**KIRKLEES METROPOLITAN COUNCIL  
INVESTMENT & REGENERATION SERVICE**

Reference No:	<b>2025/62/91442/W</b>
Site Address:	34, Moor Lane, Netherthong, Holmfirth, HD9 3UW
Description:	Demolition of existing garage and erection of single storey front and two storey side extensions and associated alterations
Recommending Officer:	Joshua Merriman

## HOUSEHOLDER DELEGATED REPORT

<b>Application Number</b>	2025/91442
<b>Location</b>	34, Moor Lane, Netherthong, Holmfirth, HD9 3UW.
<b>Proposal</b>	Demolition of existing garage and erection of single storey front and two storey side extensions and associated alterations.
<b>Publicity end date</b>	17/07/2025
<b>Number of representations received</b>	1.
<b>Kirklees Local Plan Allocation/Designation</b>	The application site is allocated within a bat alert layer and a twice buffer.
<b>Extension to Time (EoT)</b>	No
<b>Recommendation</b>	Conditional Full Permission

CLIENT			
MR & MRS P HOGAN			
PROJECT			
PROPOSED EXTENSION AND ALTERATIONS 34 MOOR LANE NETHERTHONG			
DRAWING TITLE			
PROPOSED ELEVATIONS			
Rev.	Notes	Date	Drawn
•	•	•	•
SCALE	1:50 AT A1	03.25	A.D.
PROJECT No.	DRAWING No.	Rev.	
2523	04	-

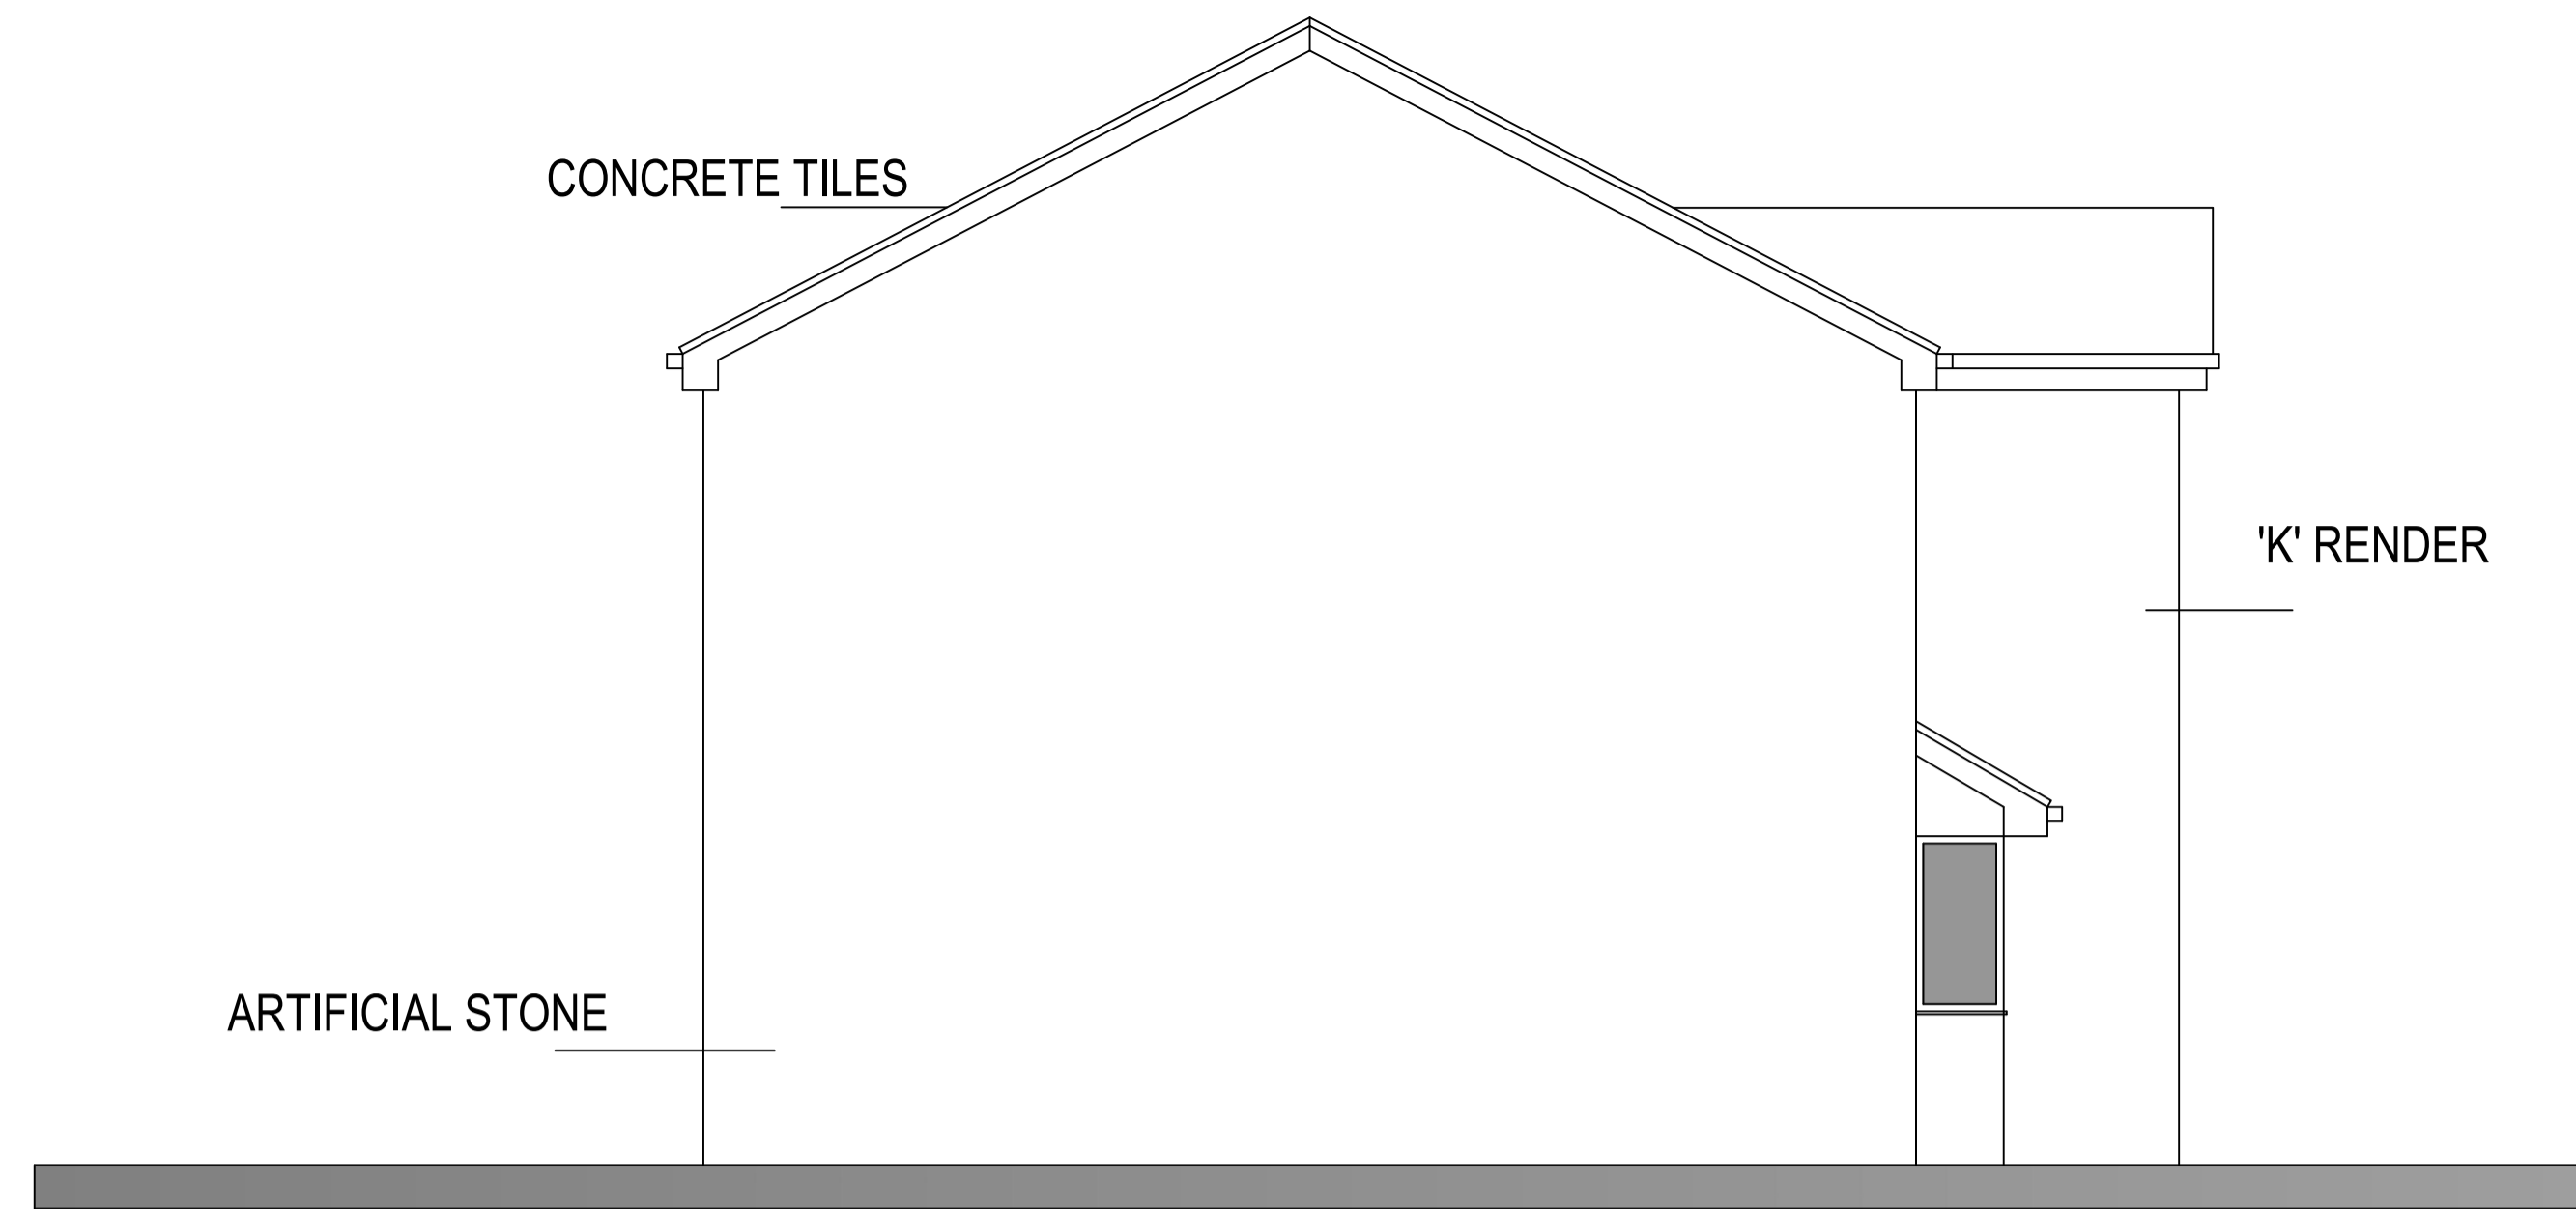
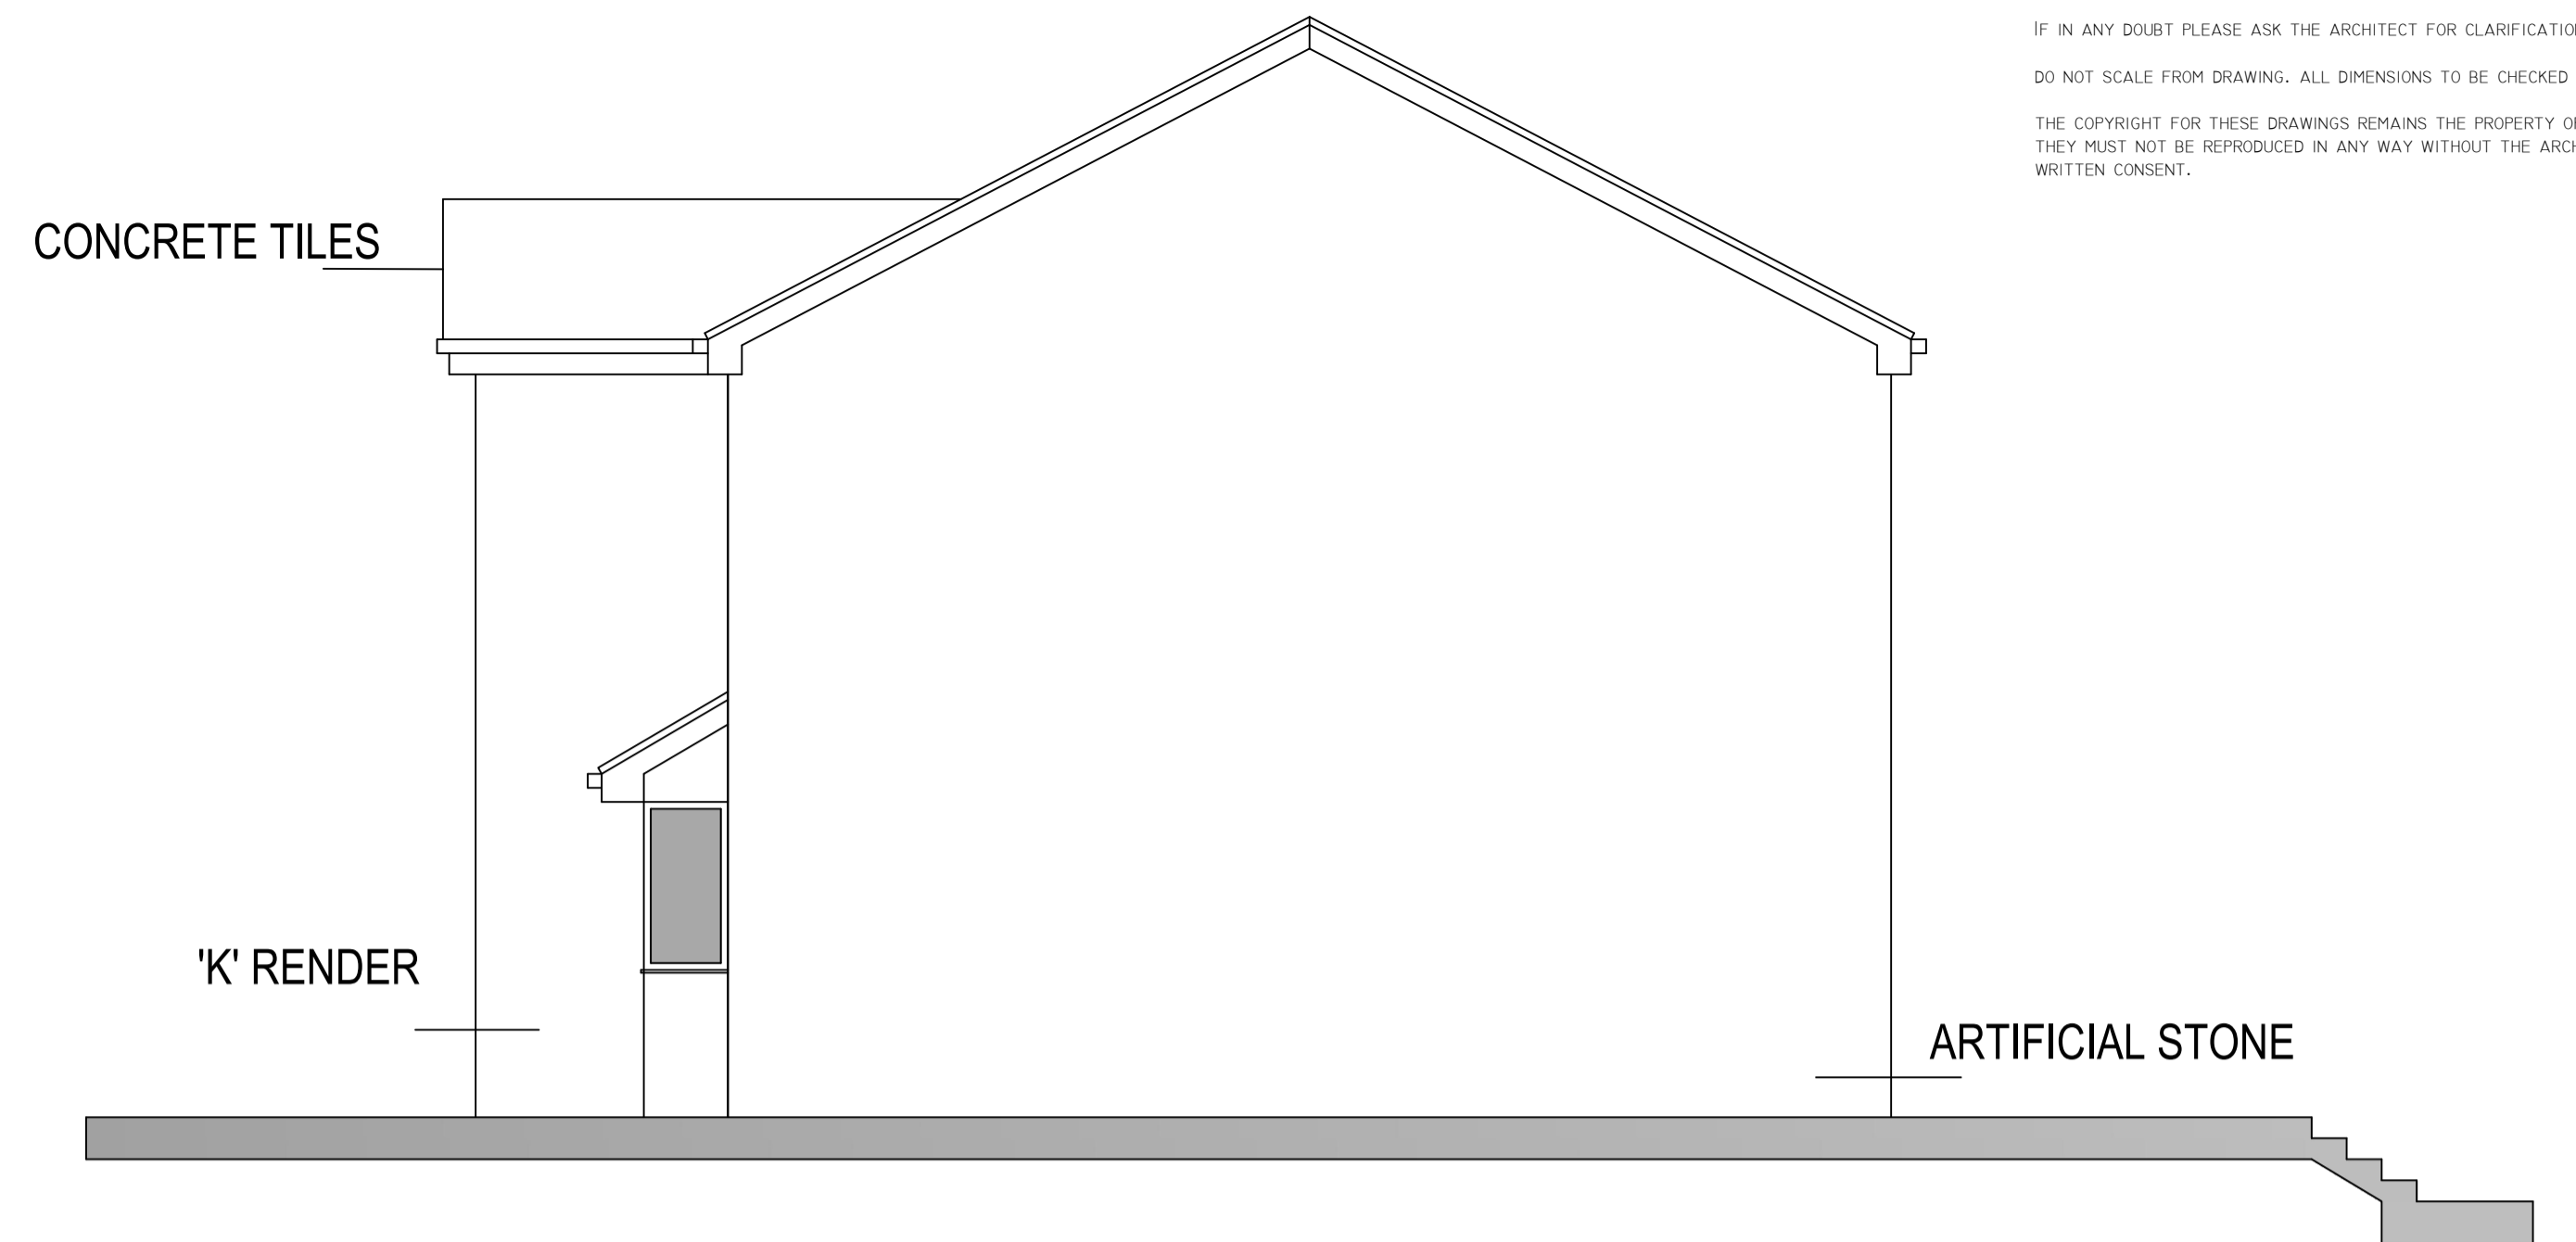
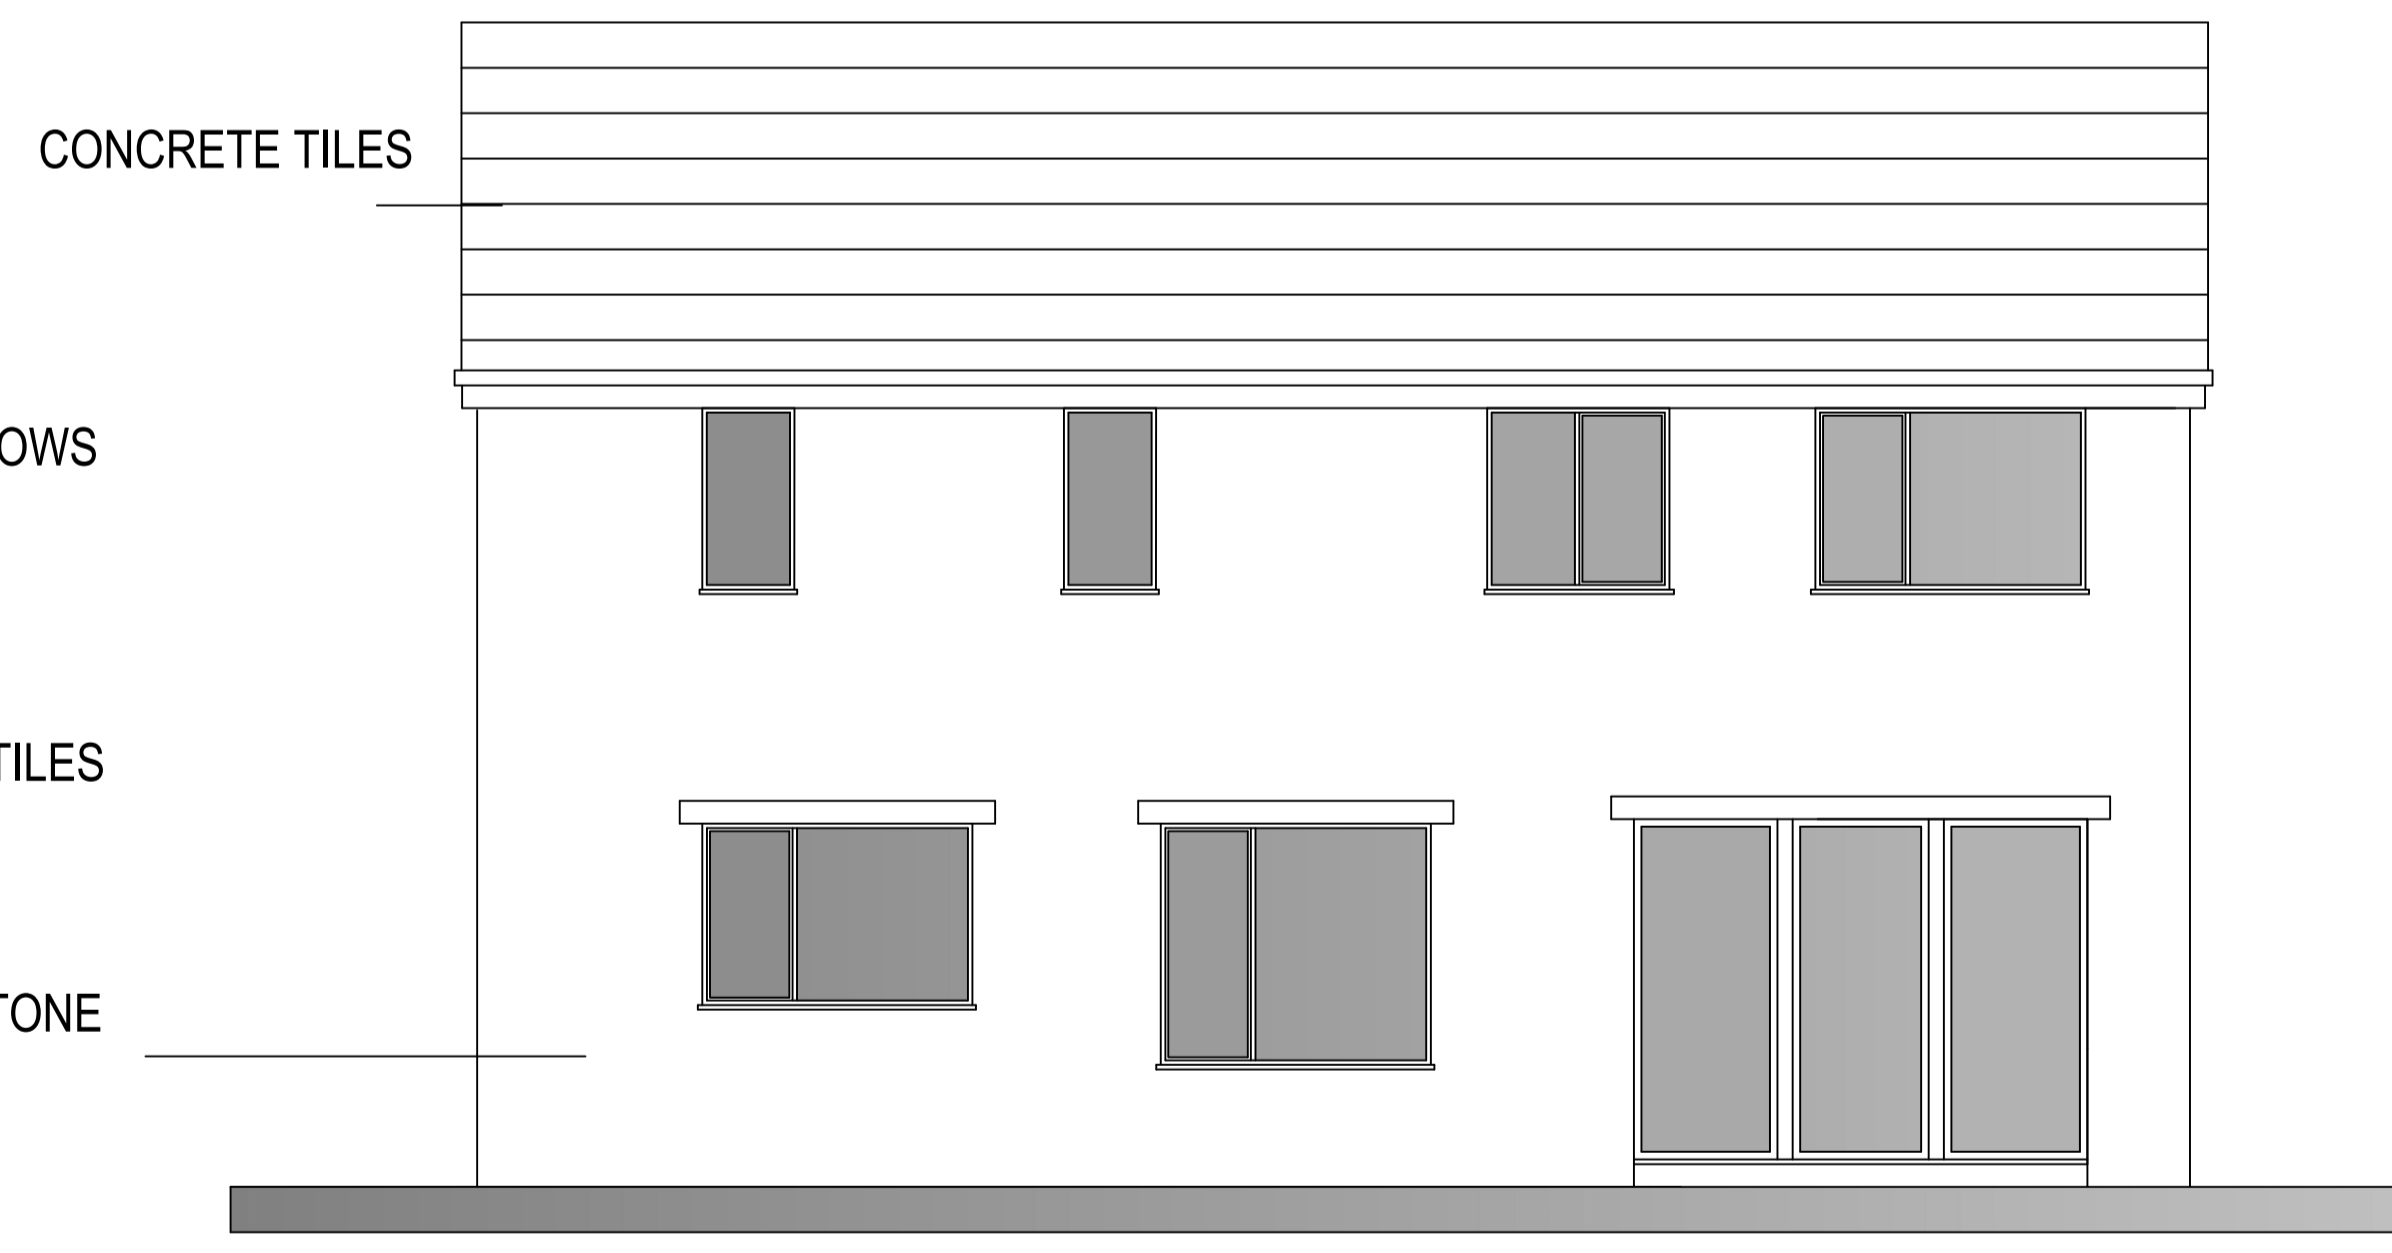
<b>YES / NO</b>	<b>SUMMARY</b>
Negotiations/Amendments during course of application	Yes	Amendments were recommended to be considered on the basis of concerns about the visual impact of the initially proposed two-storey front extension and materials of construction. The applicant submitted amended plans to address these concerns.
Parish/Town Council comments sought	Yes	Holme Valley Parish Council have stated they have no comments on the application, deferring to Kirklees officers.
Planning History	Yes	2004/92139 – Erection of two storey and single storey extension – Conditional Full Permission.
Consultations required	No

The proposed front extension will project 2.04m from the front elevation of the original house, with a maximum height of 3.49m, eaves height of 2.23m, and a width of 2.94m.

The proposed two storey side extension will project approximately 6.02m from the side elevation of the existing building, with a maximum height of 7.84m, eaves height of 5.28m, and a depth of 8.3m – All matching the existing building.

case is not considered to have a significantly greater impact to the existing dwelling.	
Facing materials and detailing	<ul style="list-style-type: none"> <li>• KDP 9 of the SPD</li> <li>• Policy LP24 Design (d) (iii) of the KLP</li> <li>• Chapter 12 of the NPPF</li> </ul>	Both extensions will be faced in artificial stone and use uPVC windows to match the existing building. Condition recommended.	✓
Roof style	<ul style="list-style-type: none"> <li>• KDP 1 and 2 of the SPD</li> <li>• Policy LP24 Design (a), (c) and (d) of the KLP</li> <li>• Chapter 12 of the NPPF</li> </ul>	A pitched, gable concrete tiled roof will be used to match that of the host property.	✓
Window proportions	<ul style="list-style-type: none"> <li>• KDP 1 and 2 of the SPD</li> <li>• Policy LP24 Design (a), (c) and (d) of the KLP</li> <li>• Chapter 12 of the NPPF</li> </ul>	All windows proposed in the dwelling are considered to be proportionate to those existing with regard to size and positioning.	✓
